Block 11, Central Park

Additional Information Response – October 2015

In response to email requests from the DPE between 2 and 13 October 2015.

TITLE  
PLANS  
Basement Level 01

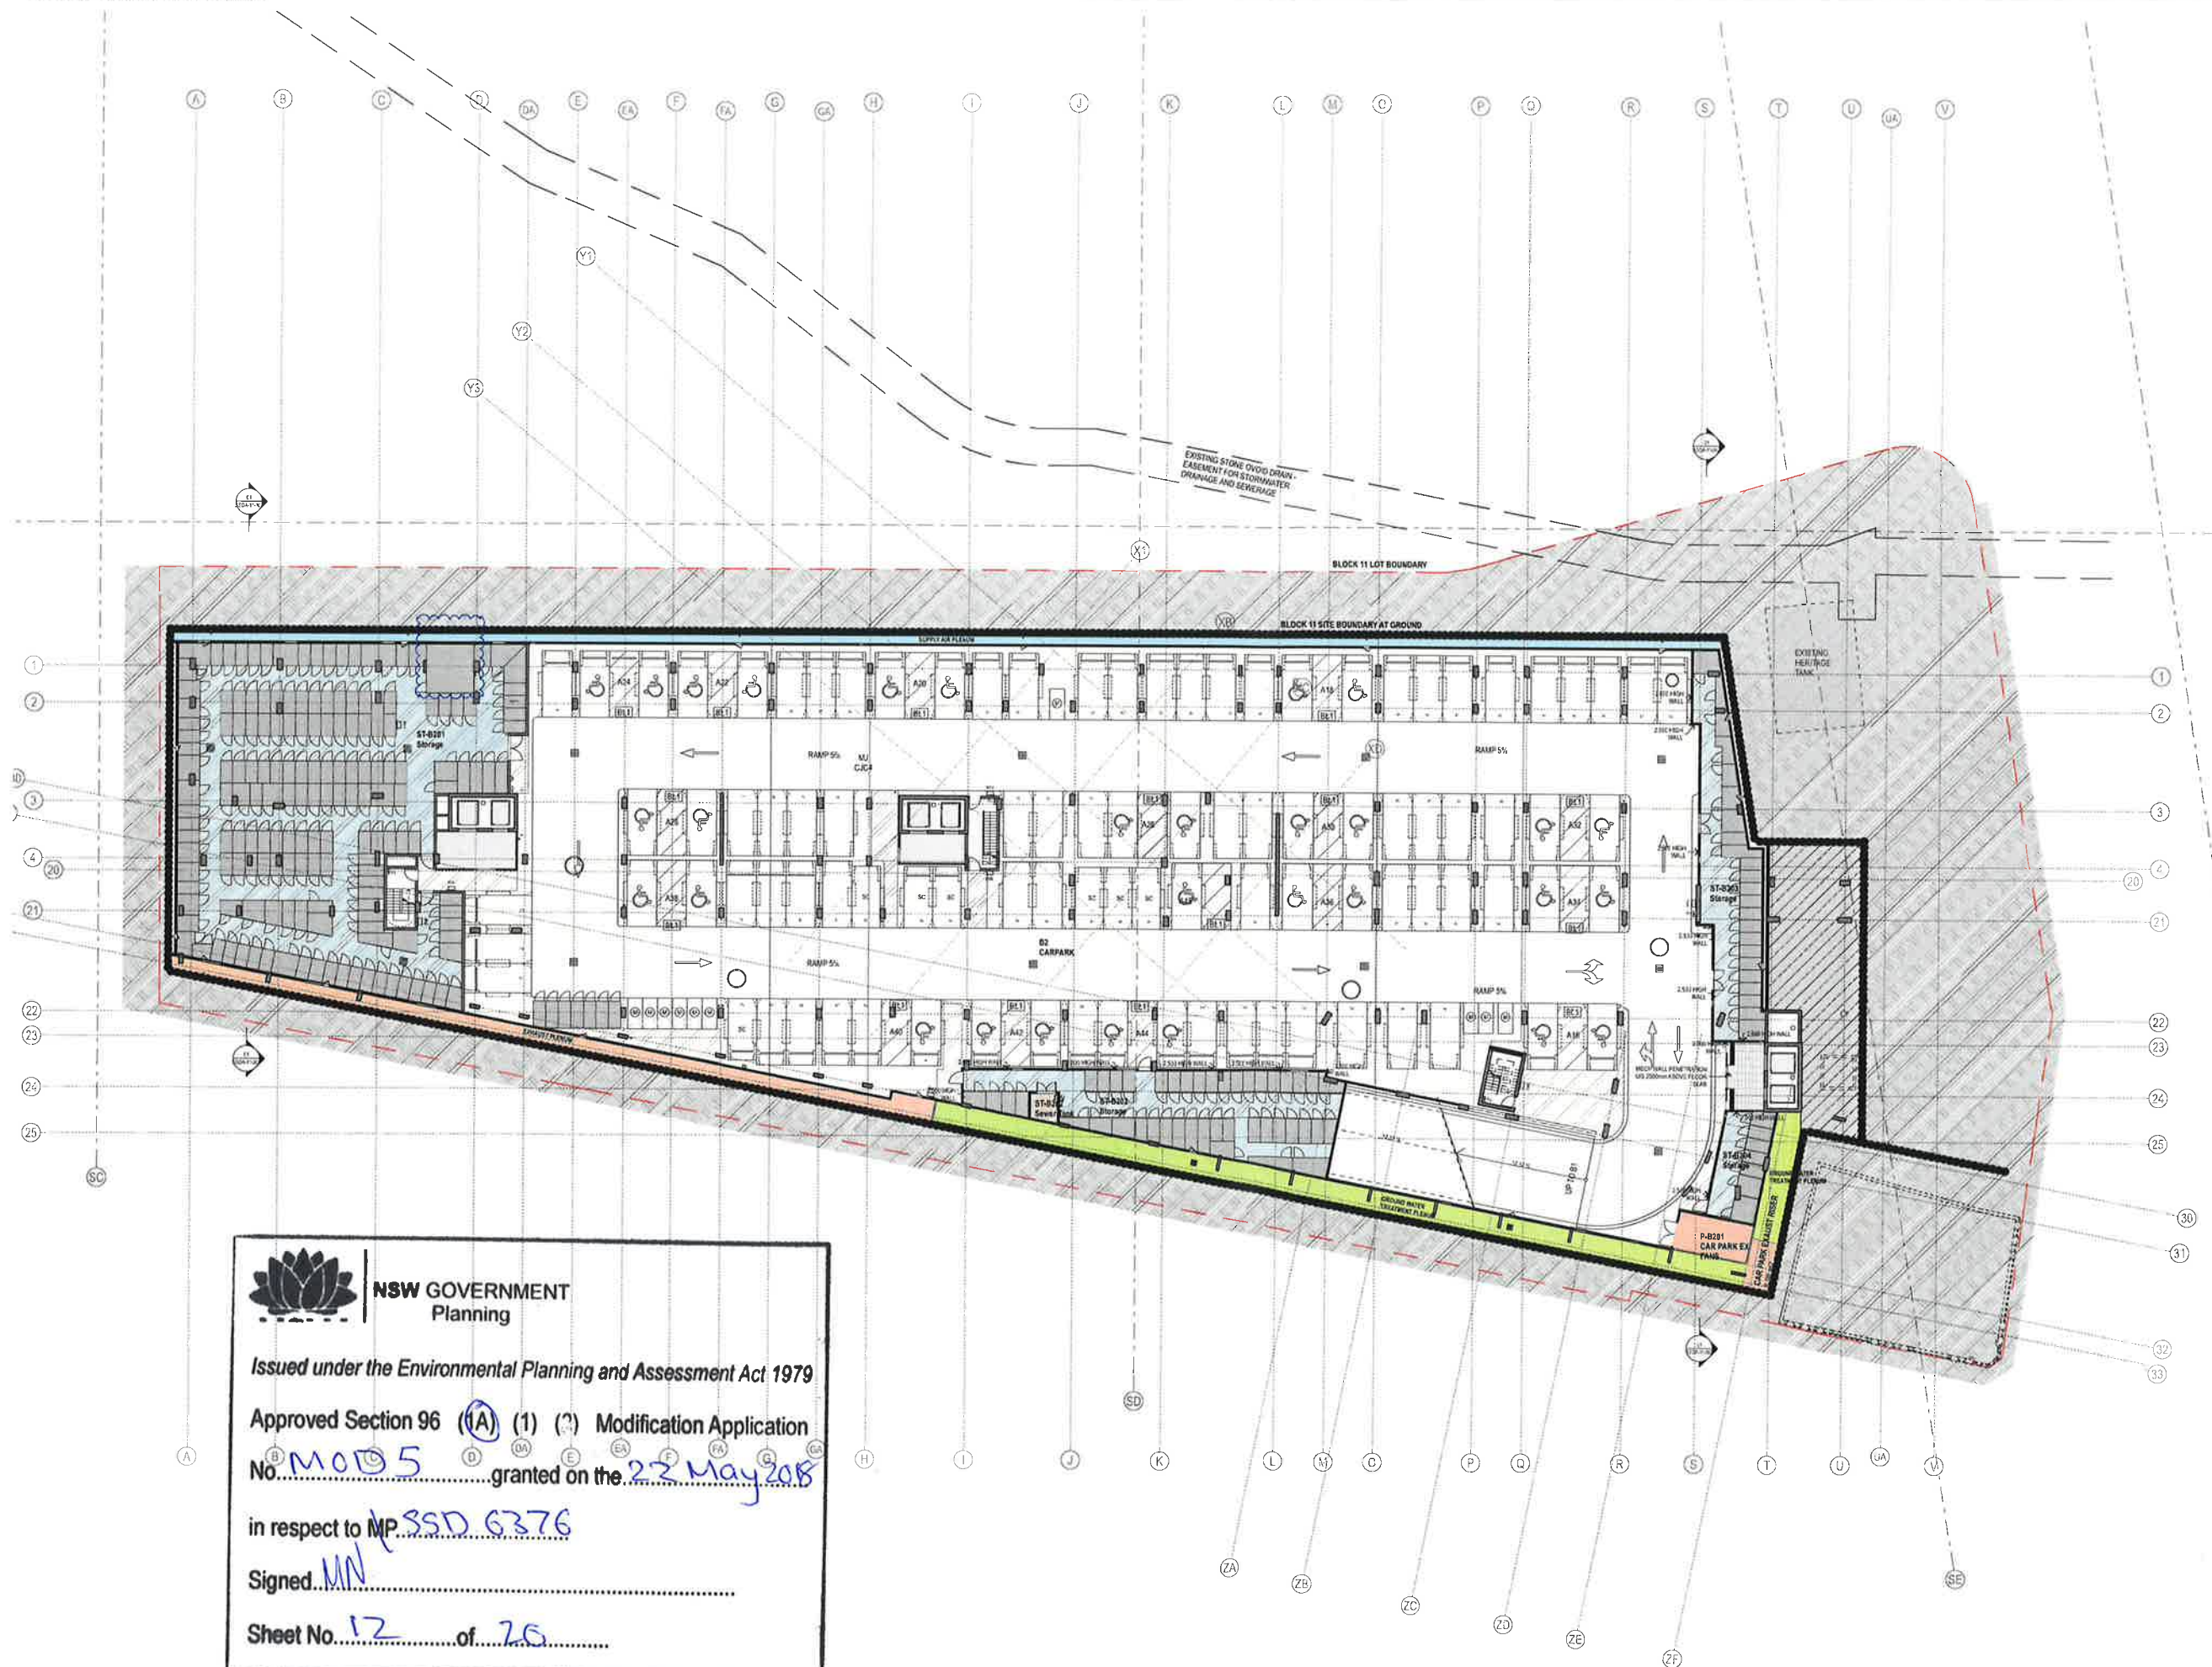
State Significant Development		
5	- the Revised Development Schedule should be checked for accuracy. The car and bicycle parking listed does not reflect the RtS and should be updated. Furthermore, additional clarification is required of: - whether the proposed four childcare car parking spaces include or exclude the on-street short term pick up/drop off spaces; - whether the 157 car parking spaces include or exclude the four childcare spaces (and pick up/ drop off spaces);	- A revised development schedule is attached that is consistent with the architectural plans provided. - The total number of car parking spaces provide within the development is 174 + 13 motorcycle spaces and 2 service vehicles as shown on the Architectural Plans and Development Schedule - In response to the two questions: - The four childcare spaces exclude the on-street short term pick up and drop off spaces on Kensington Street - The 174 car parking spaces (as confirmed on the revised and updated Development Schedule) excludes the on-street short term pick up and drop off spaces on Kensington Street

Bicycle Parking - Confirmation of the number of Bicycle Parking spaces provided - the Development Schedule suggests a total of 416 bicycle spaces, which does not correspond with what is proposed in the RtS at page 12. - Furthermore, it appears that the retail heritage floorspace (323sqm) is not included in the retail bicycle parking calculation. The schedule should be updated to reflect what is proposed	- Confirming that the number of bicycle parking shown in the Development Schedule are correct and supersede the reference to bicycle parking in the RTS – the total being 448. - The location of the bicycle parking spaces are shown on the revised Architectural Plans attached (basement and ground floor) - The retail heritage floor space (Castle Connell Hotel) has been included in the allocation of retail parking, and is reflected on the revised Development Schedule attached. - The total number of bicycle parking spaces proposed is broken down below for clarity: Total Bicycle Parking: 448 - Residential bicycle parking: 296 - Residential Visitor: 102 - Retail Employee: 30 - Retail Visitor: 14 - Childcare Bicycle Employee: 2 - Childcare Visitor: 4 - The proposal meets or exceeds the minimum required bicycle parking provision for each use within the development. - In addition to the numbers above and included on the Development Schedule, an area of non-allocated residential storage (capable of string an additional 34 bicycles) is included on Basement Level 01. This are may be utilised by residents for additional bicycle storage if required). - The proposal complies with the relevant provision of the DCP – namely Control 3.11.3 (2)(a) which states that" <i>(2) Bike parking spaces for new developments are to be provided in accordance with the rates set out in Table 3.5 On-site bike parking rates, except where:</i>
